CITY OF ALBUQUERQUE

May 16, 2024

Re: Quik Trip No. 7001
521 Unser Blvd. NW
Traffic Circulation Layout
Engineer's/Architect's Stamp XX-XX-XX (K10-D071)

SHEET NUMBER:
C100
05 OF 25

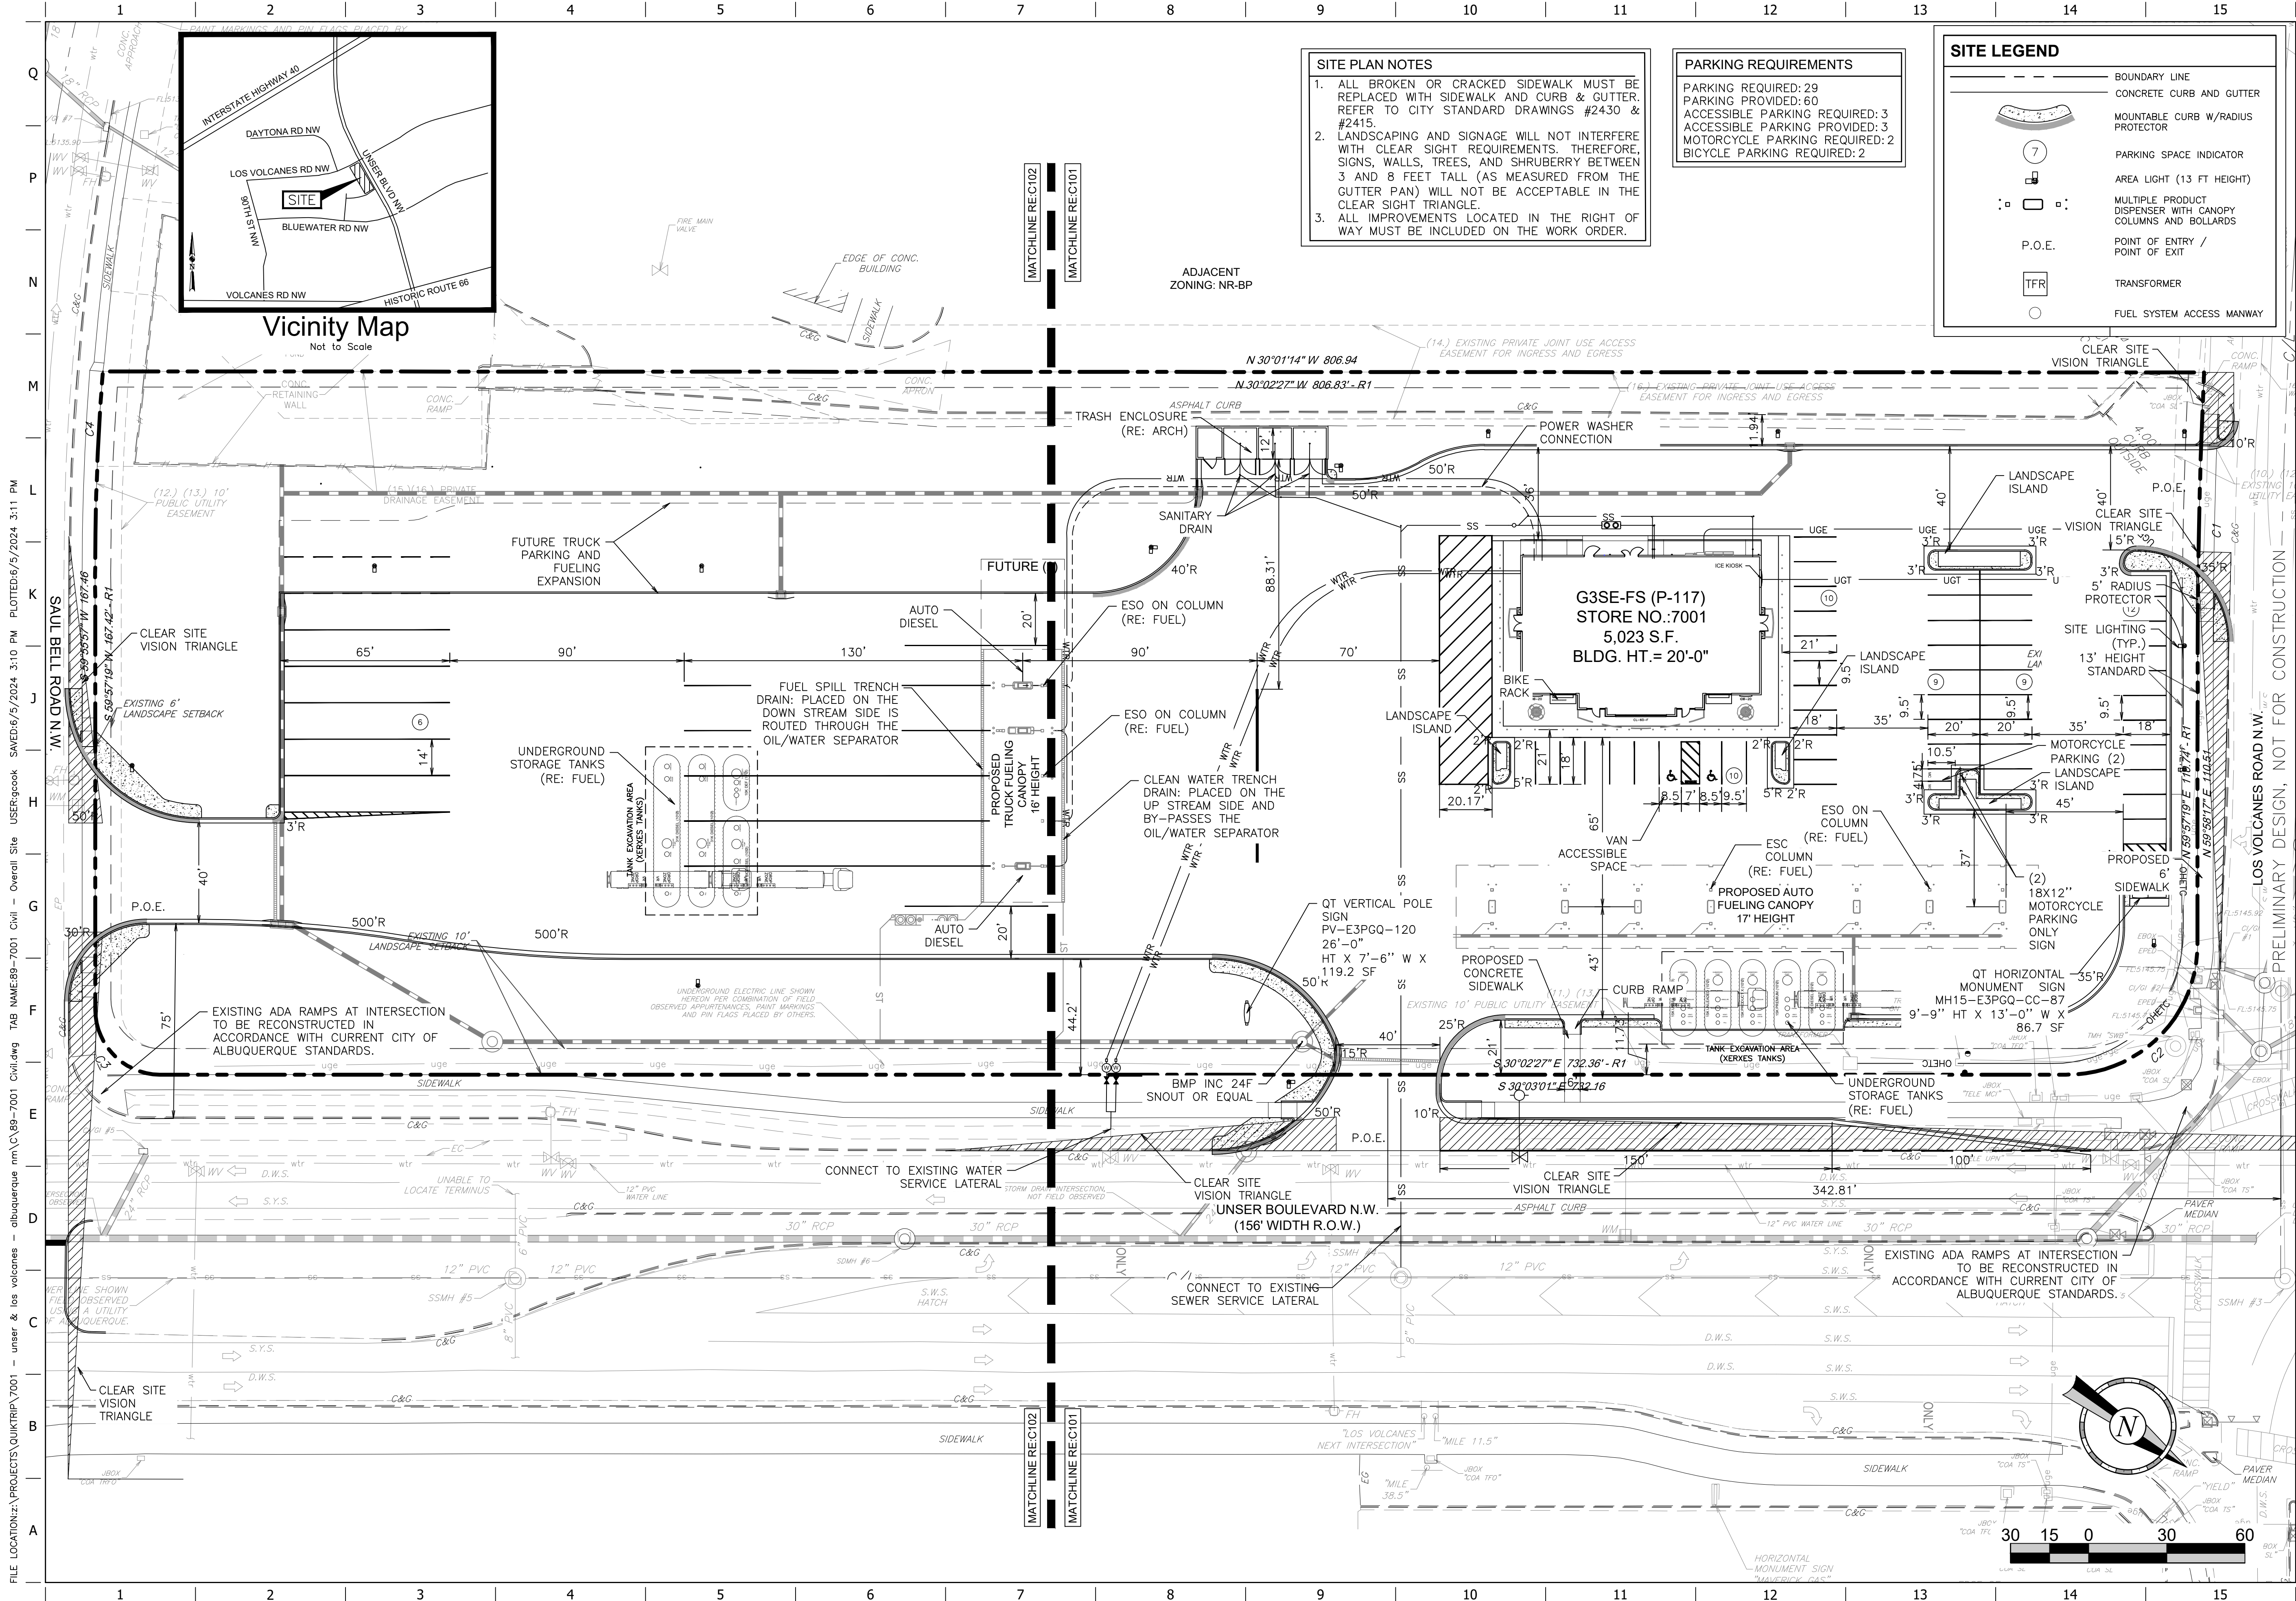
1. Please show a vicinity map on the site plan showing the location of the development in relation to streets and well-known landmarks.
2. The traffic circulation layout must be stamped, signed, and dated by an engineer or architect licensed in the state of New Mexico.
3. List the number of Motorcycle and Bicycle parking spaces required by the IDO.
4. A minimum 6 ft. wide sidewalk must be developed off Los Volcanes Rd. please provide details and reference city standard drawing 2430. See attached for reference.
5. A minimum 5 ft. wide sidewalk must be developed off Saul Bell Rd. please provide details and reference city standard drawing 2430. See attached for reference.
6. The minimum distance from the intersection to site access off Saul Bell Rd. is 75 ft. please show this dimension on the site plan.

SHEET NUMBER:
C102
07 OF 20

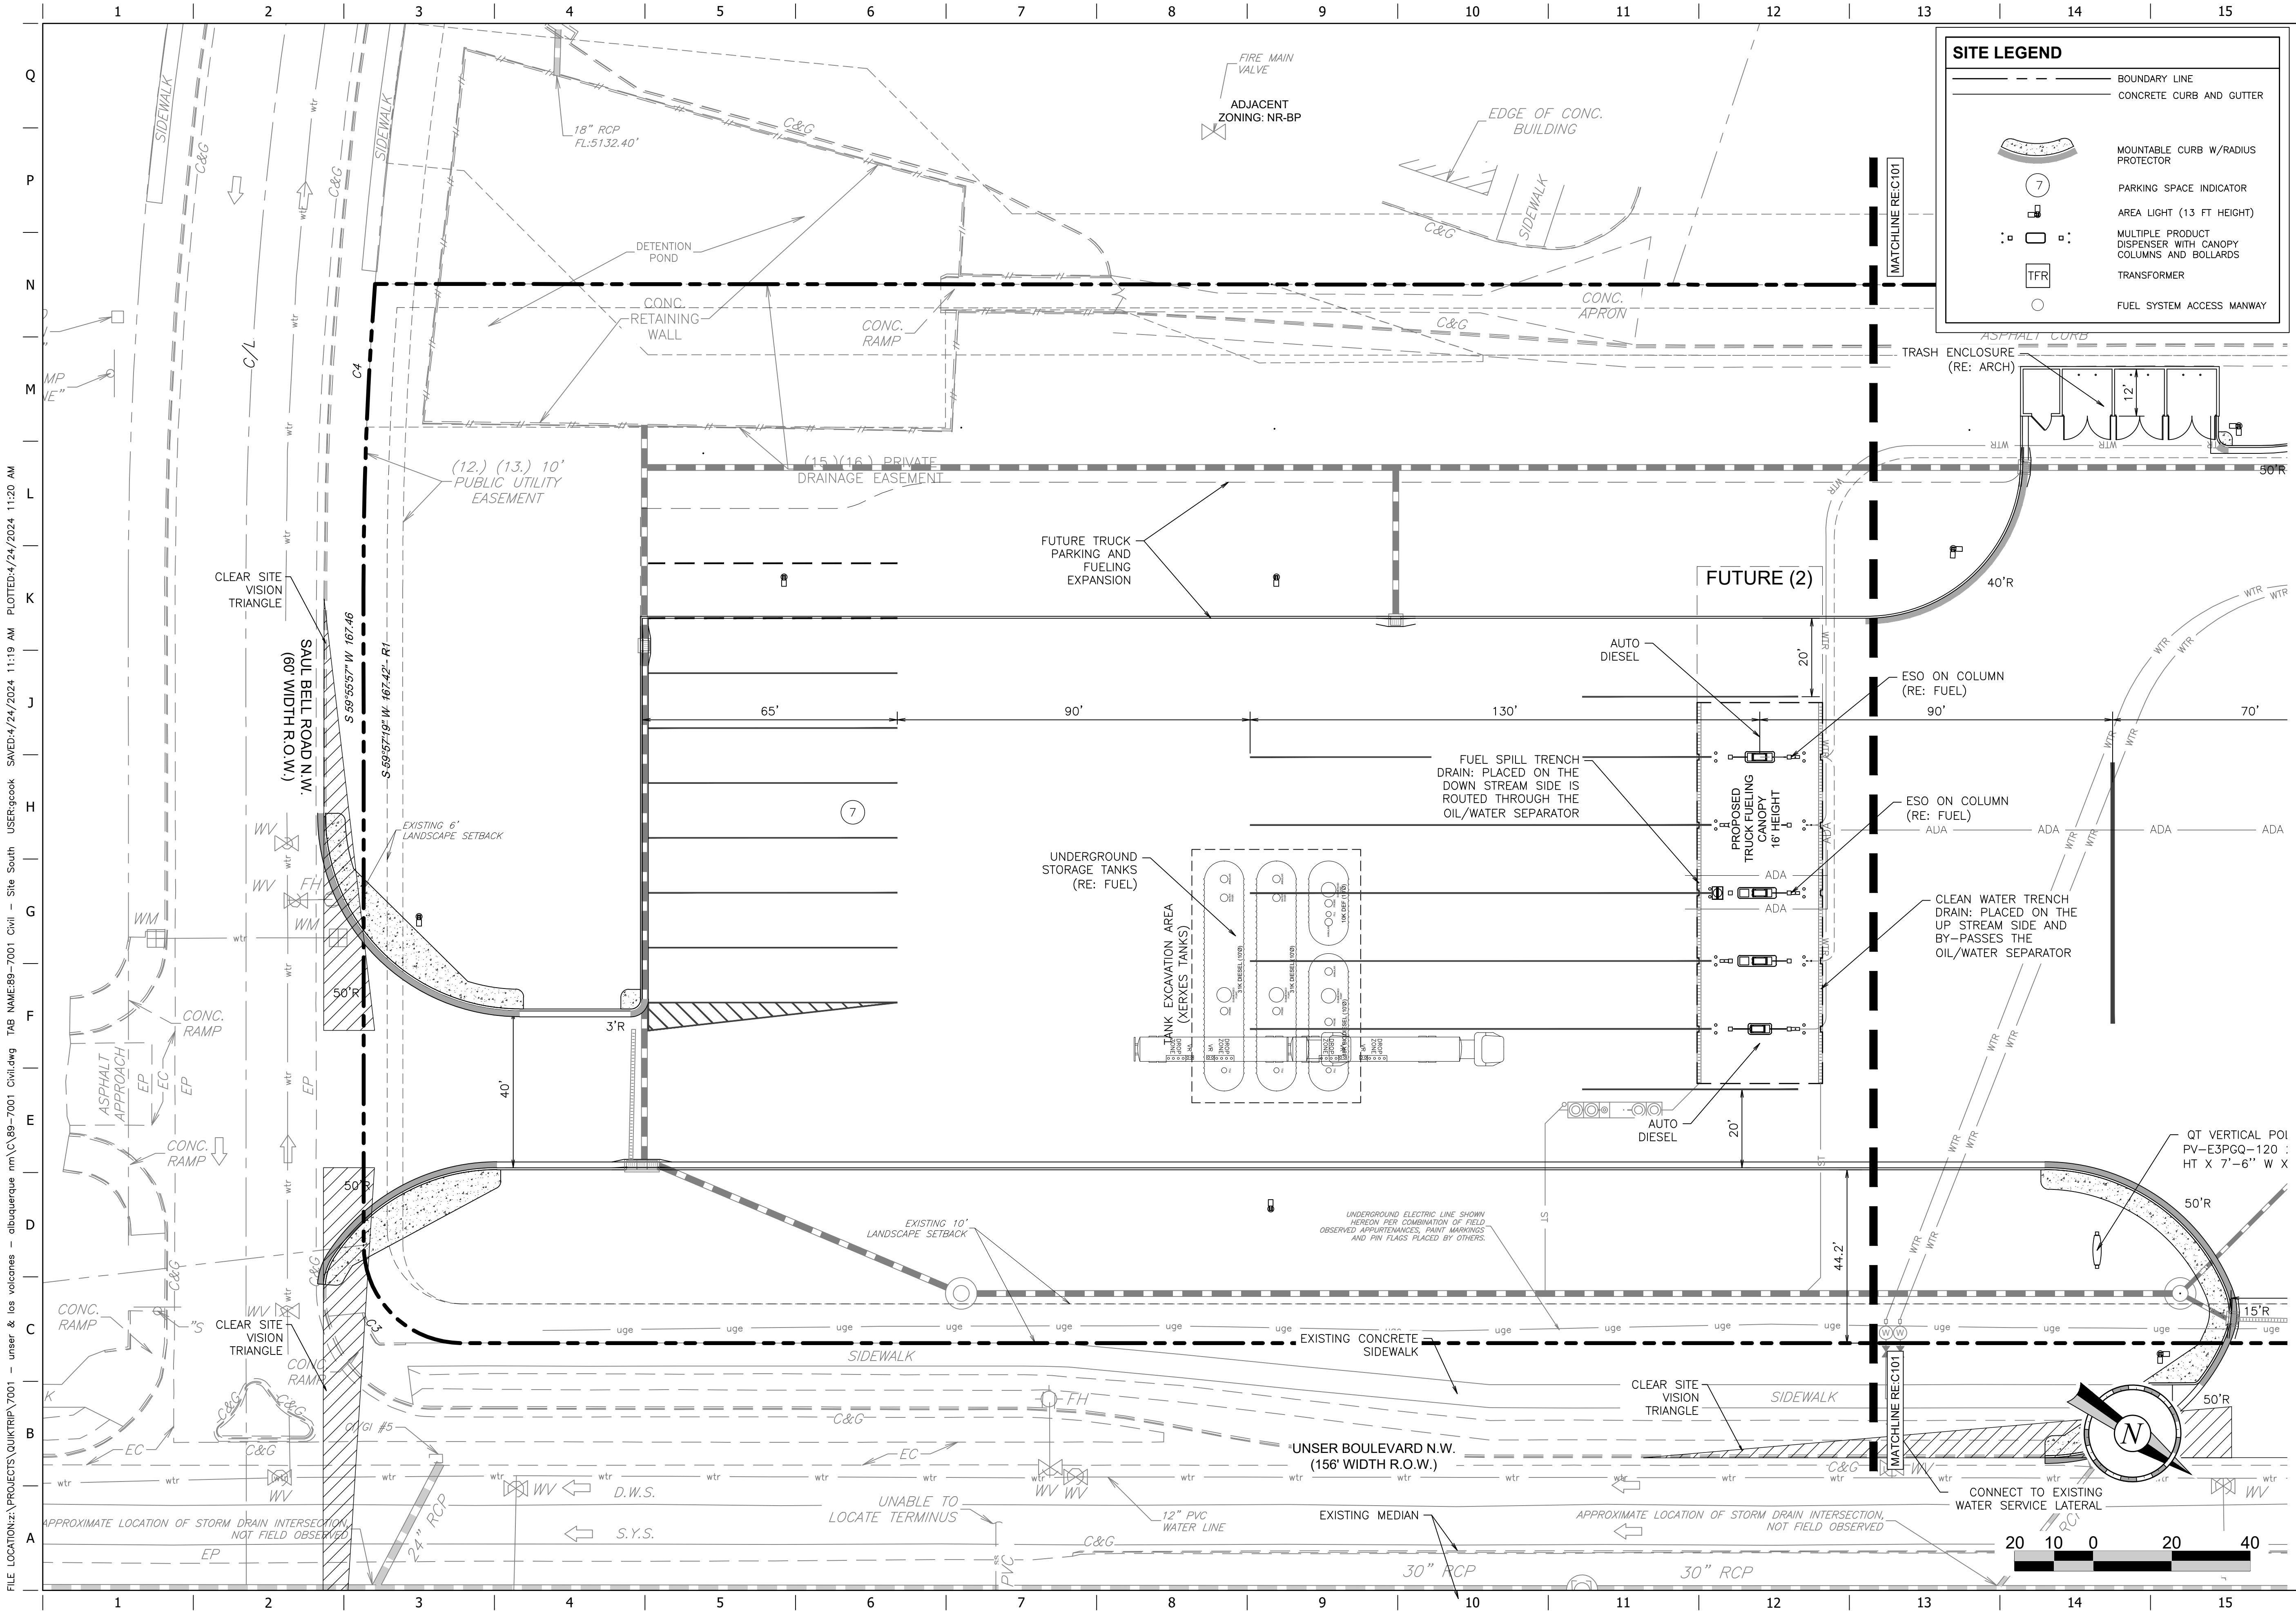
8. ADA curb ramp at the corner of Unser Blvd and Saul Bell Rd. must be updated to current standards and have truncated domes installed.

9. ADA curb ramp at the corner of Unser Blvd and Los Volcanes Rd. must be updated to current standards and have truncated domes installed.

14. The pavement marking "MC" should be shown in the opposite direction for motorcycles entering the parking space.
15. All bicycle racks shall be designed according to the following guidelines:

19. Per the IDO, a 6 ft. wide ADA accessible pedestrian pathway is required from the public sidewalk to the building entrances. Please clearly show this pathway and provide details.

20. Per DPM, a 6 ft. wide ADA accessible pedestrian pathway is required from the ADA parking stall access aisles to the building entrances. Please clearly show this pathway and provide details.

21. ADA accessible pedestrian pathway should not be placed behind parking space or adjacent to a vehicular way. Vehicle and pedestrian/wheel chair conflicts should be avoided as much as possible.
